**PLAN REVIEW SHEET**

**Petition #:** RZP 2021-258

**Address:** Neal Rd.

**Request:** R-12 MF (CD)

REZONING SITE PLAN

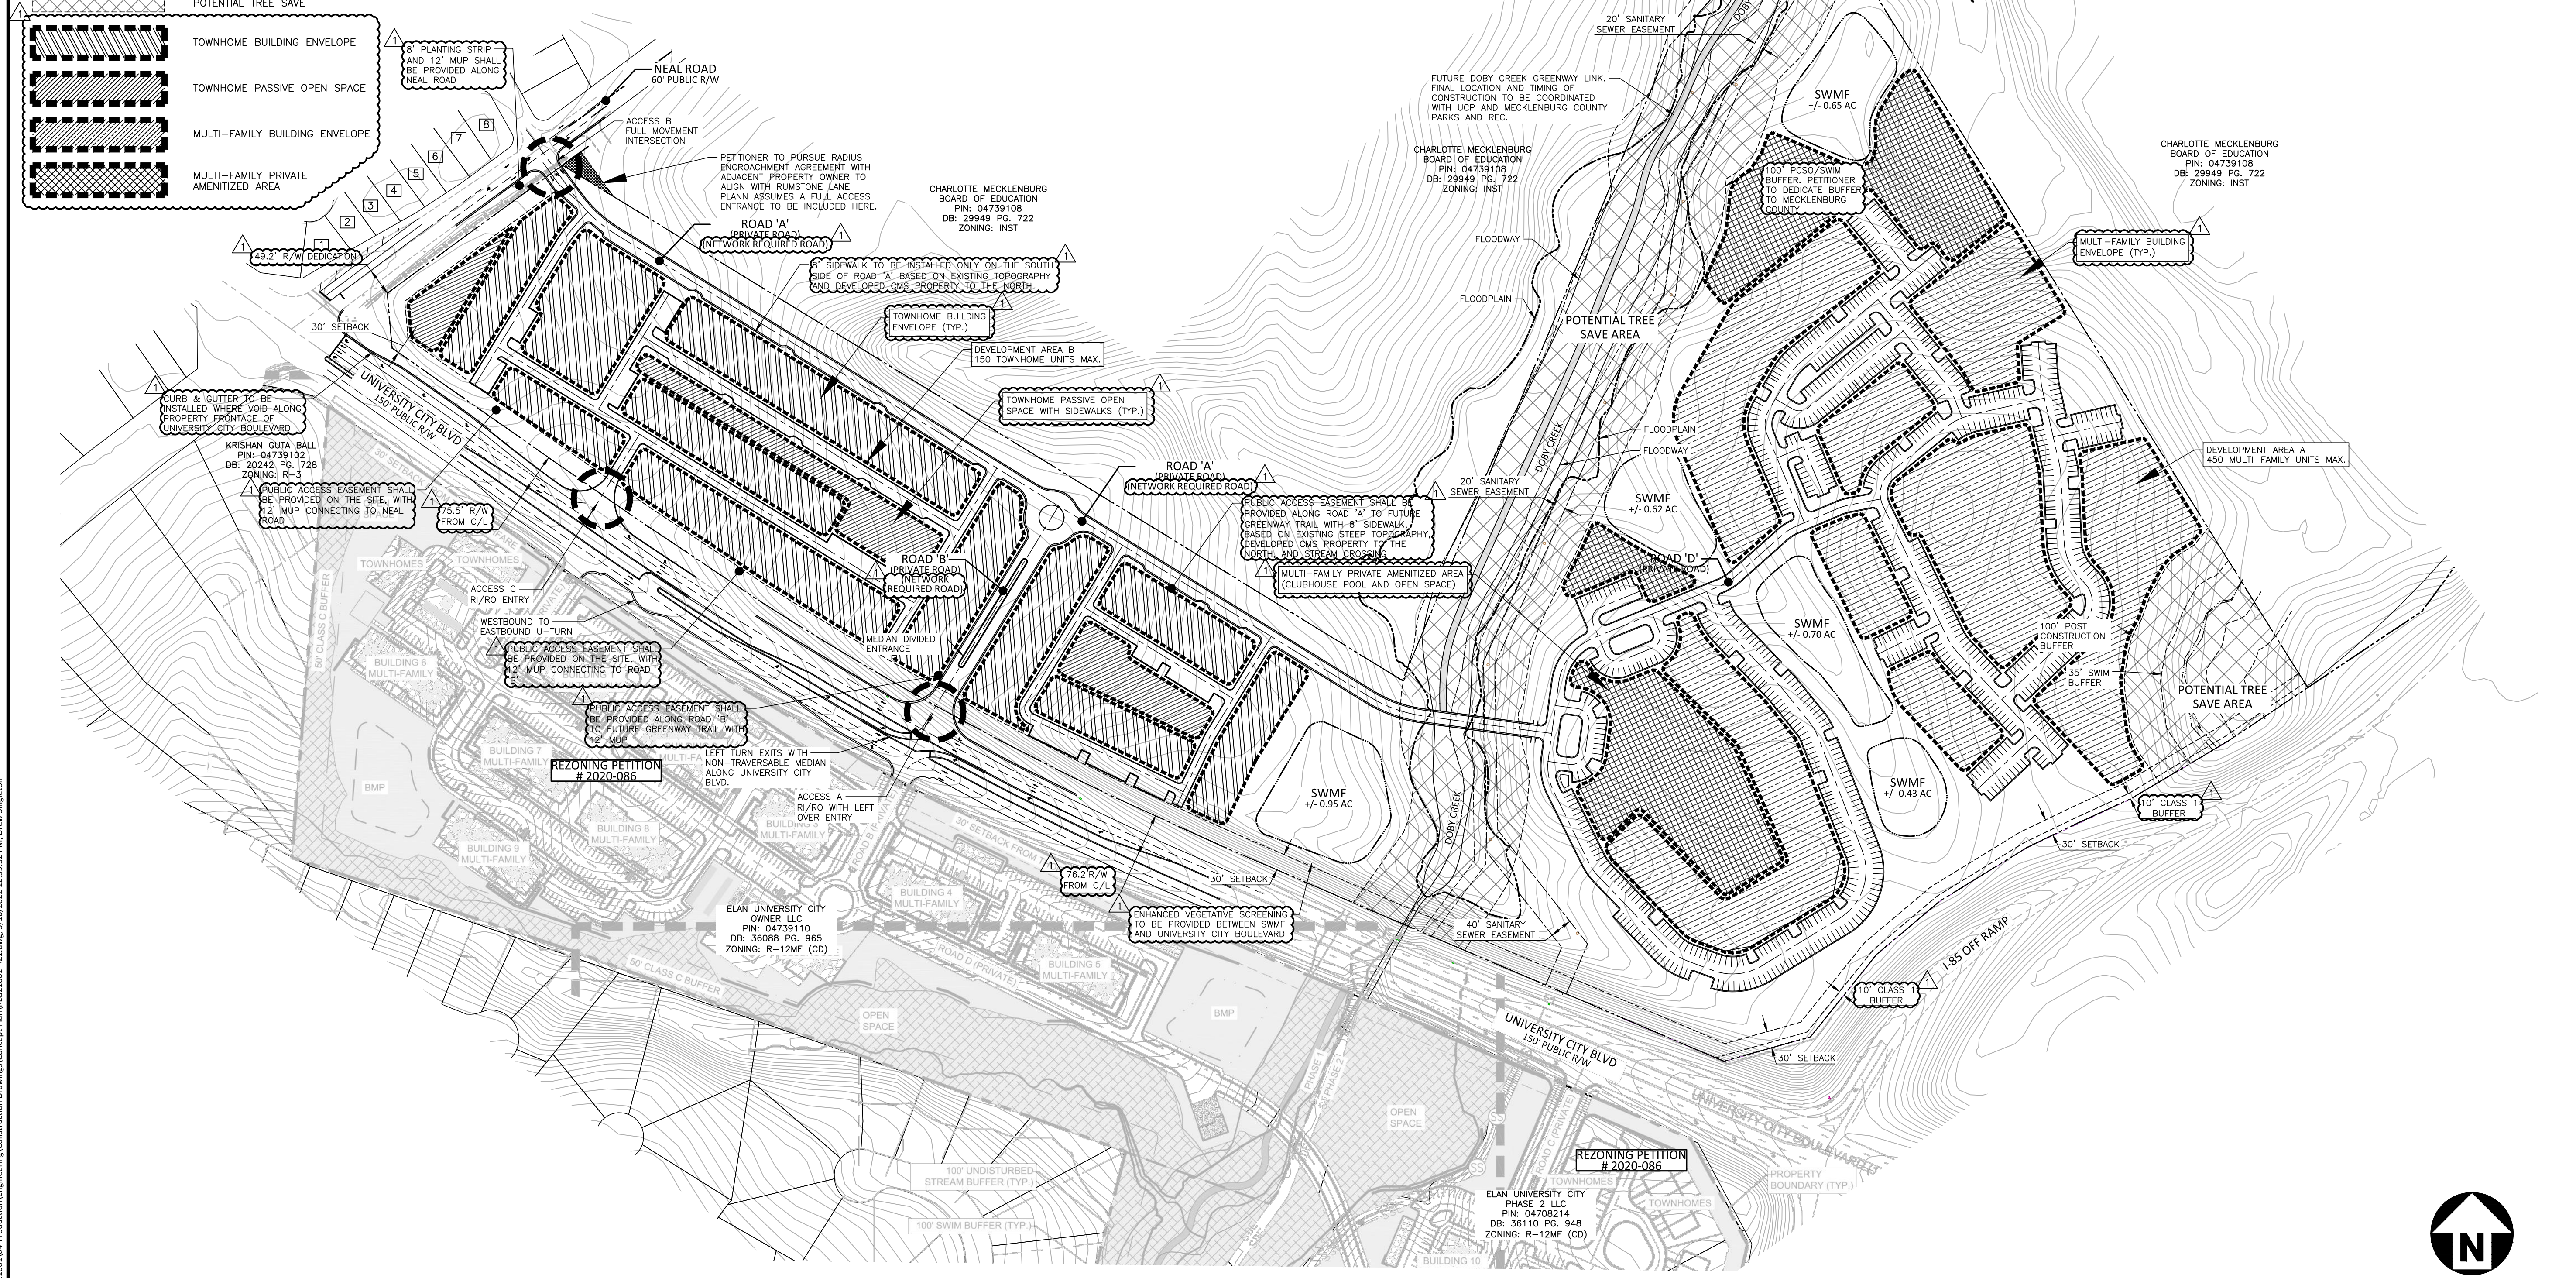
The site is located along CATS local bus route #54 on Neal Road. CATS requests the construction of an ADA compliant waiting pad per Land Development Standard 60.01B on Neal Road. The final location of the pad will be coordinated with the developer through the permitting process.
